From: [Aaron Walsh](#) on behalf of [Town Planning LNE](#)
To: [Planning](#)
Subject: 6/2023/1086/HOUSE - Full Application at Postern Gate Farm Newgate Street Village Hertford SG13 8QR
Date: 30 June 2023 14:55:20
Attachments: [image001.png](#)
[Standard Drainage Requirements.doc](#)
[Standard Informatives.docx](#)

Network Rail Consultation Response

FAO:	Chris Carter
Date:	30/06/2023
Application reference:	6/2023/1086/HOUSE
Proposal:	Erection of an outbuilding following demolition of existing outbuilding and removal of concrete blocks to vehicle crossover
Location:	Postern Gate Farm Newgate Street Village Hertford SG13 8QR

[02] BLOCK PLAN 1:500

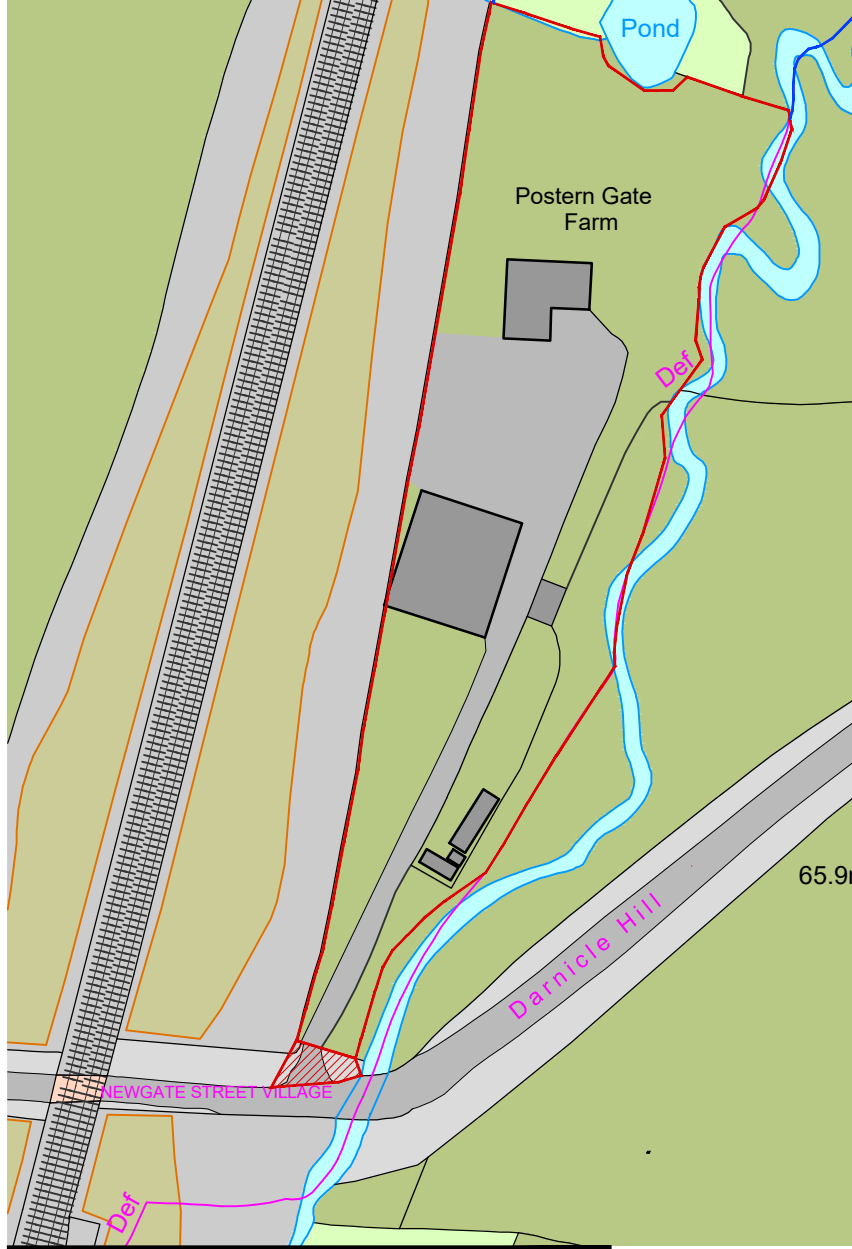
We note that proposed use of the new storage building will be for the primary use for storing vehicles. We additionally note the proposal incorporates a new access route to the south of said building.

An Armco or similar barrier or raised curbing should be located in positions where vehicles may be in a position to drive into or roll onto railway land or damage the lineside fencing. Network Rail's existing fencing / wall must not be removed or damaged.

Given vehicle movements, a provision should be made where the new access route is being implemented to the south of proposed building. This is in accord with the new guidance for road/rail vehicle incursion NR/LV/CIV/00012 following on from DfT advice issued in 2003, now updated to include risk of incursion from private land/roadways.

Given the nature of the proposals and location of turning areas/roadways, we would expect that a condition securing the design and installation of suitable vehicle incursion measure by the developer is included in any consent. This is for the safety, operational needs and integrity of the railway.
